Your Ref:  
Our Ref: 21/0784/FUL  
Date: 14 April 2021

### INVALID APPLICATION

**PROPOSAL:** ERECTION OF EXTENSION TO SOUTH ELEVATION OF DWELLINGHOUSE  
**LOCATION:** Wheatcroft Farm House, Glenlochar, Castle Douglas, DG7 2LJ

Drawing No AS-104
Wheatcroft Castle Douglas

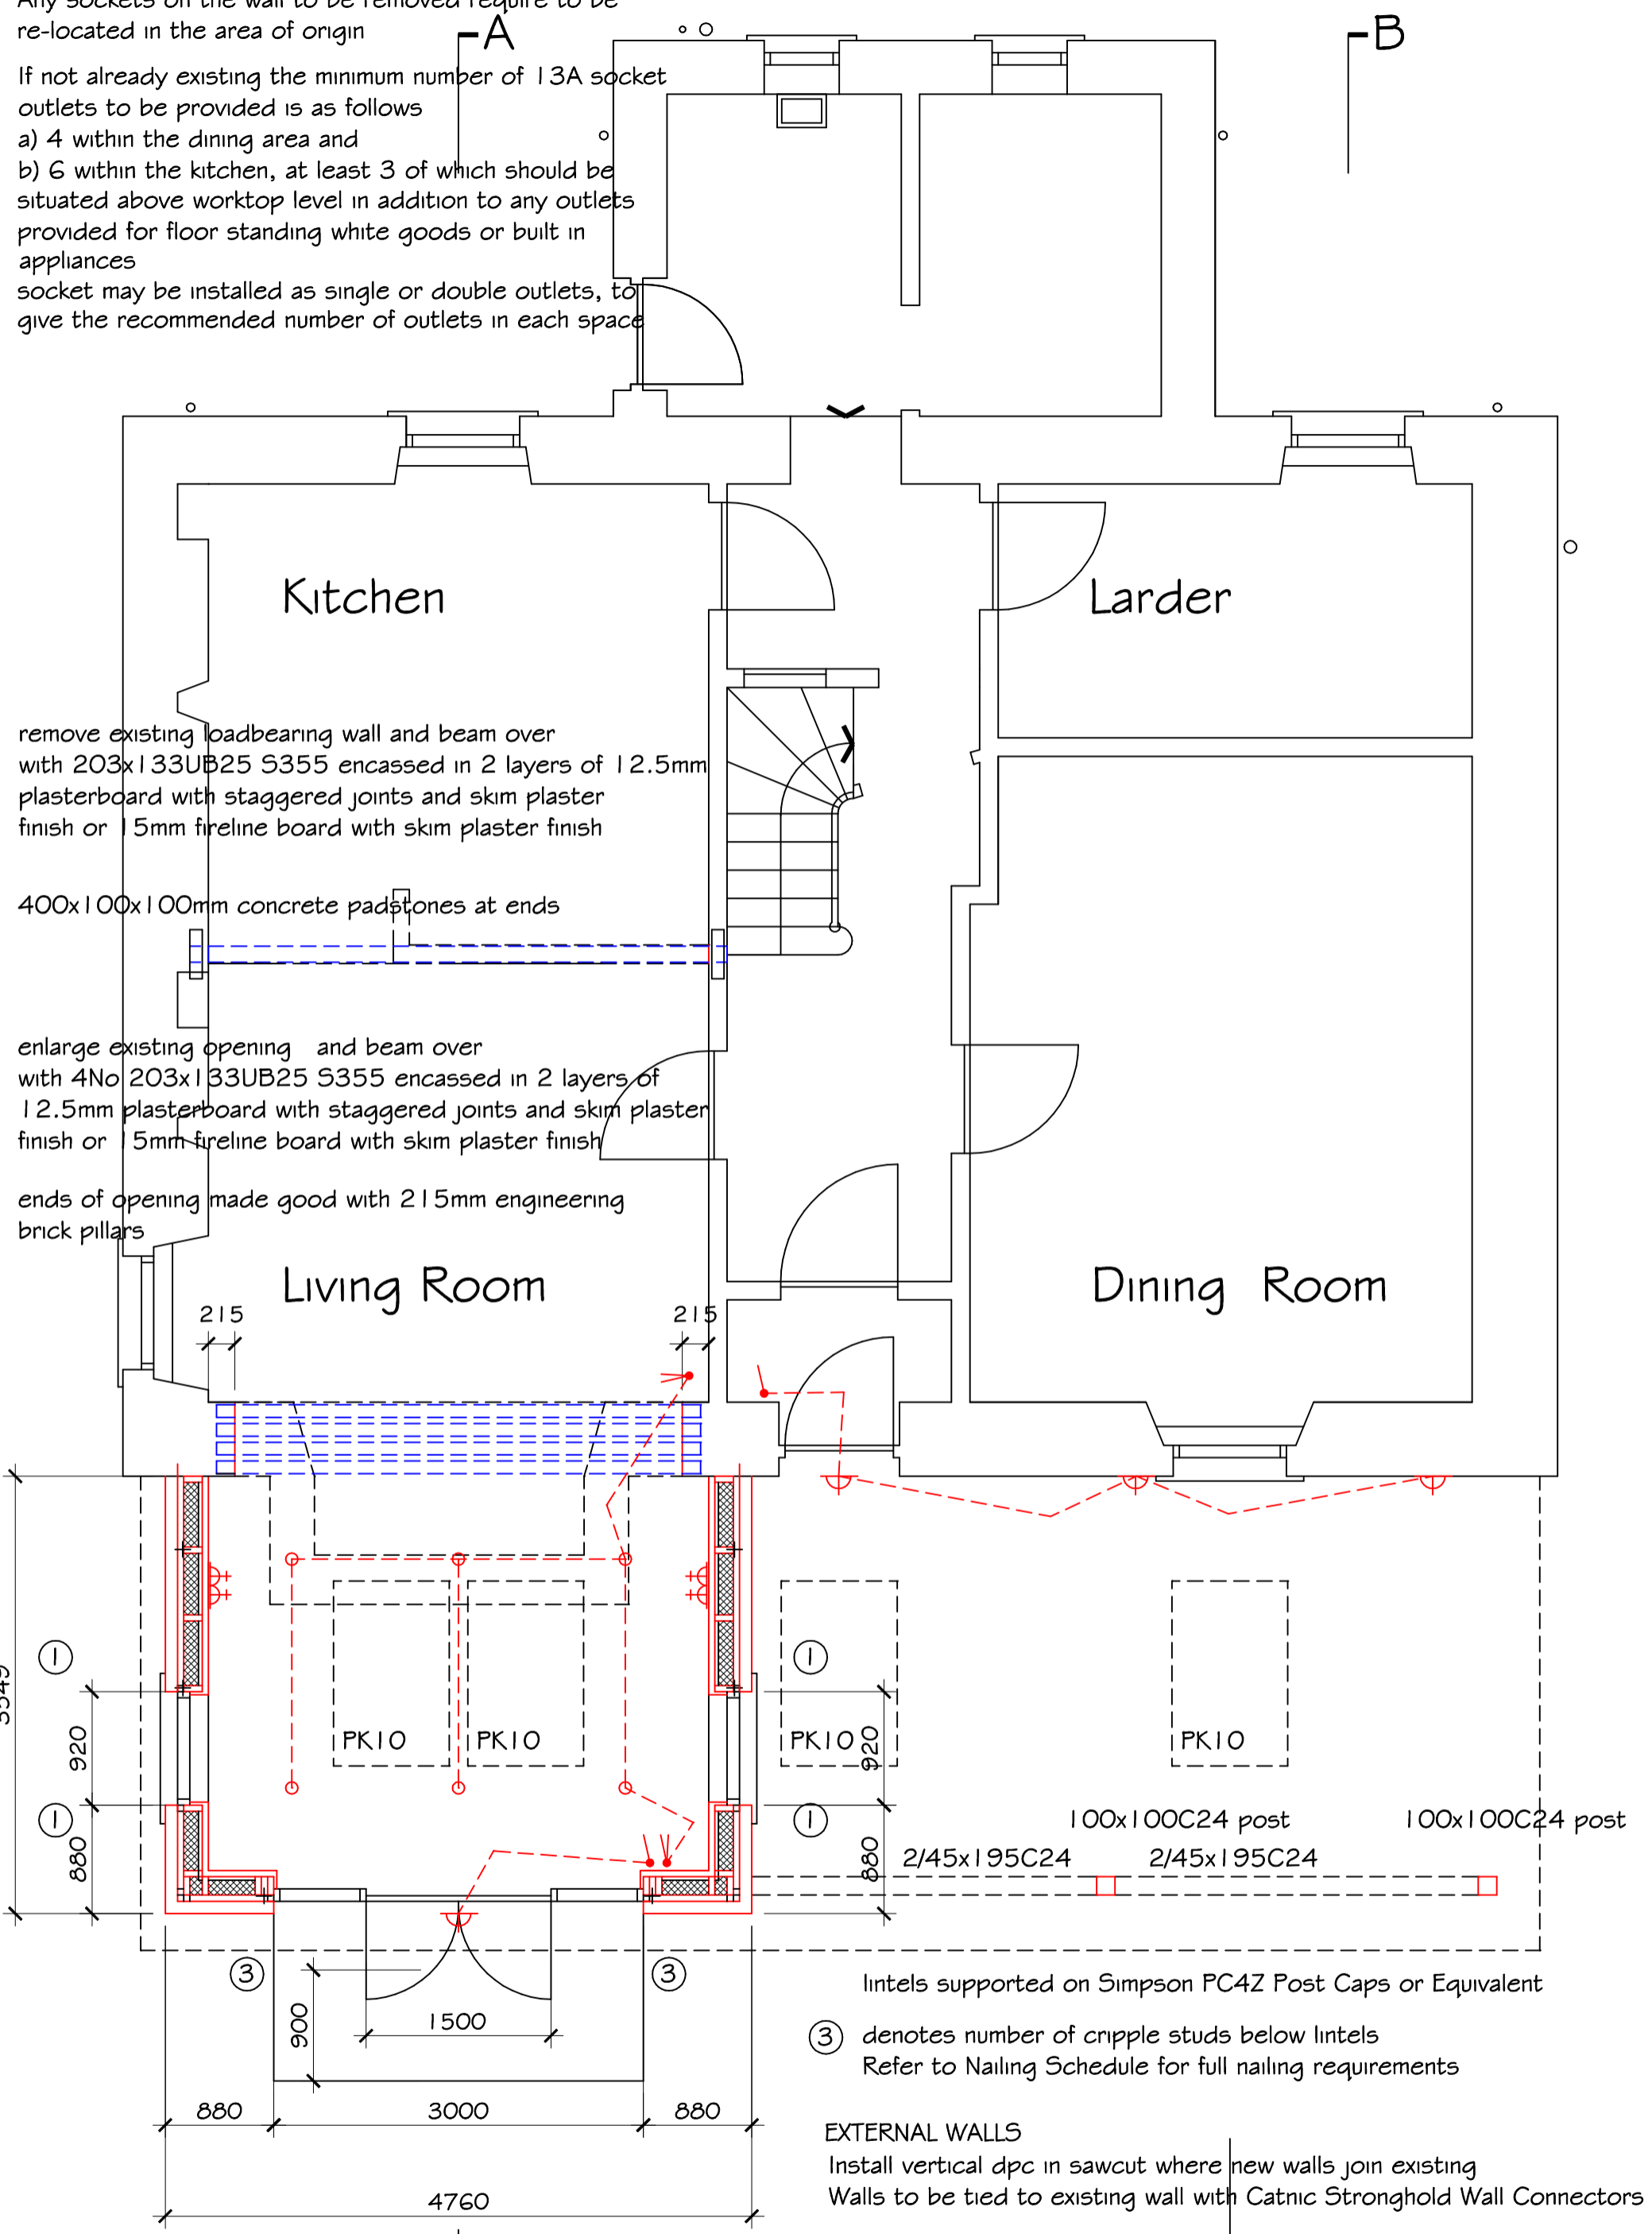
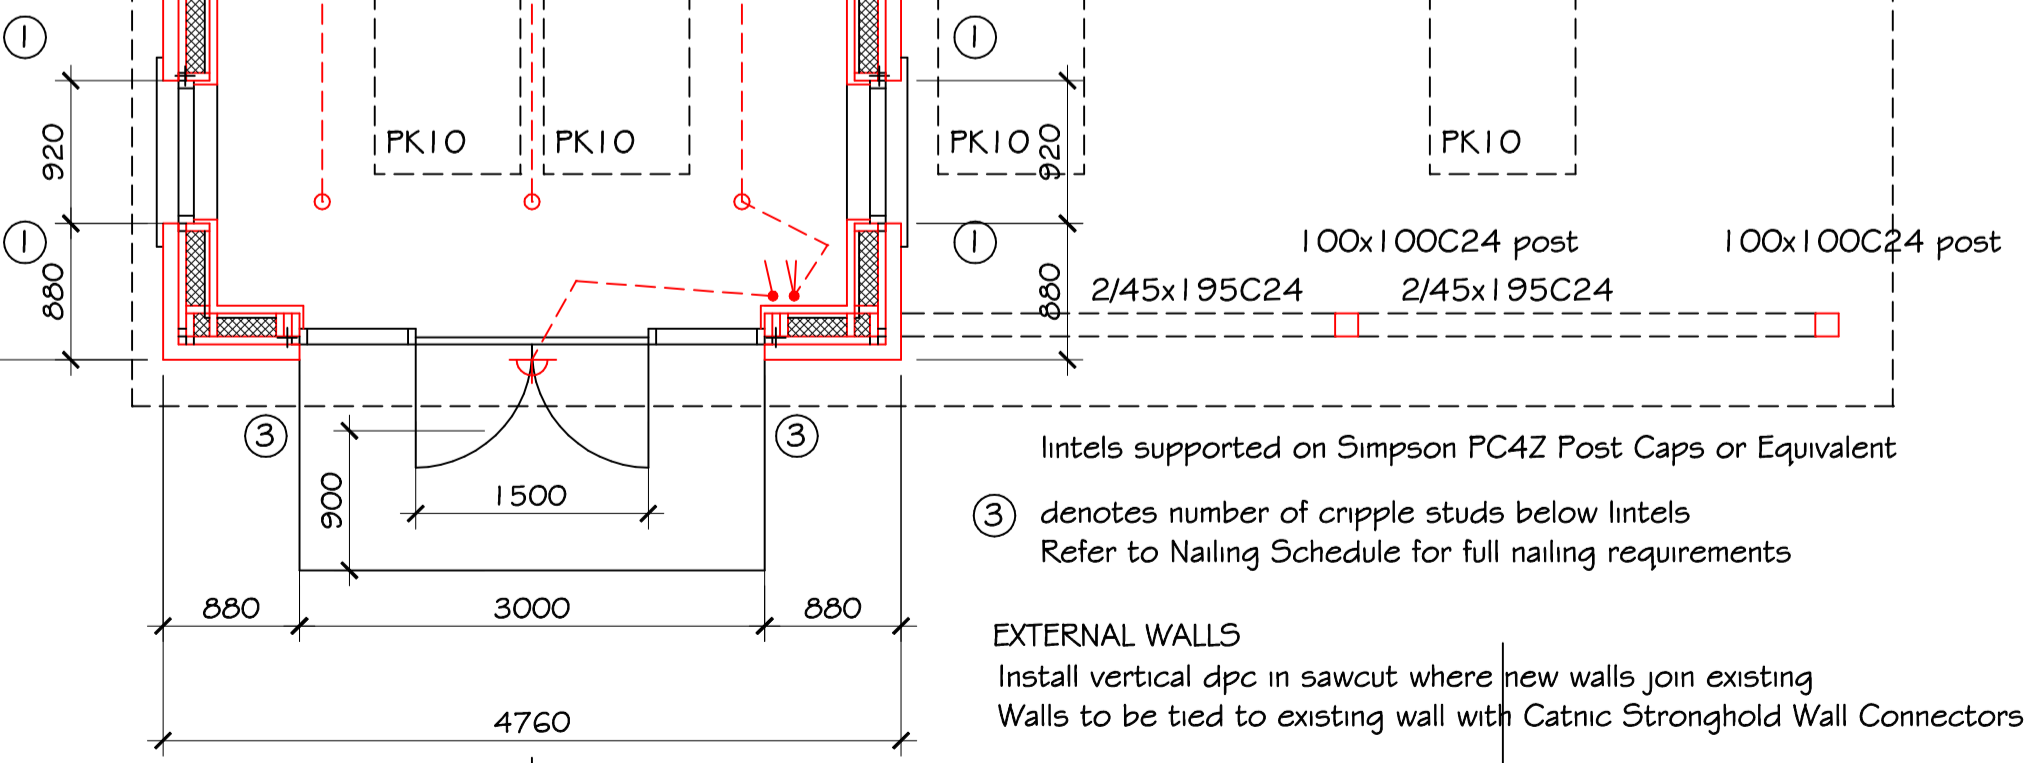
**01. The proposed ground floor plan doesn't show the full dimensions of the extension (entire lean-to extension requires consent). Please submit an amended floor plan showing the proposed dimensions of the full extension.**
